Application Reference: 6/2020/1853/COND

Proposed development at: 36 Salisbury Square, Hatfield, AL9 5AF

Proposal: Submission of details pursuant to condition 1 (sample of materials), condition 2 (glazing scheme and ventilation system) and condition 3 (parking scheme) on planning permission 6/2017/1903/FULL

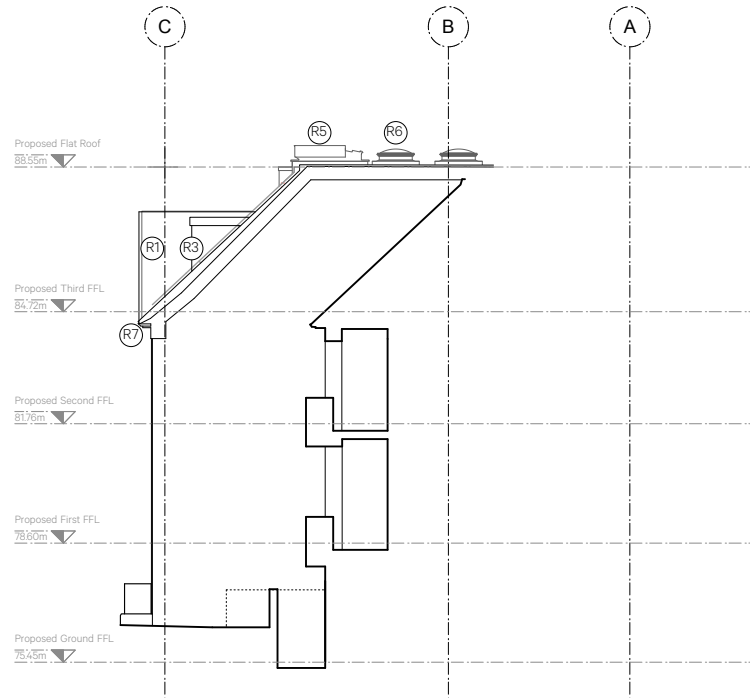
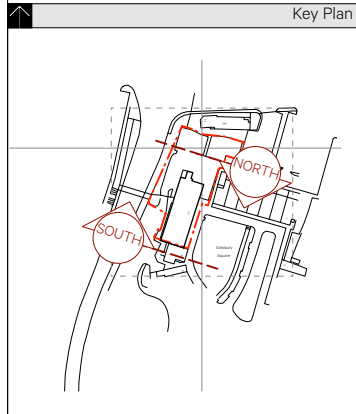
External facing materials are illustrated and annotated on submitted drawing numbers 879_PL_120 Revision P1, 879_PL_121 Revision P1, 879_PL_122 Revision P1 & 879_PL_114 Revision P1 and mistakenly includes details of proposed

In addition, the above drawings include a smoke vent (R5) and roof/access smoke ventilation (R6) on the roof of the building which did not form part of the planning permission. The applicant would need to submit a planning application to seek approval for these proposed additions.

The external facing materials relating to the roof space of the building are acceptable and approved. All other works and external facing material details included in the submitted drawings are not required by condition 1 and are not relevant to the planning permission.
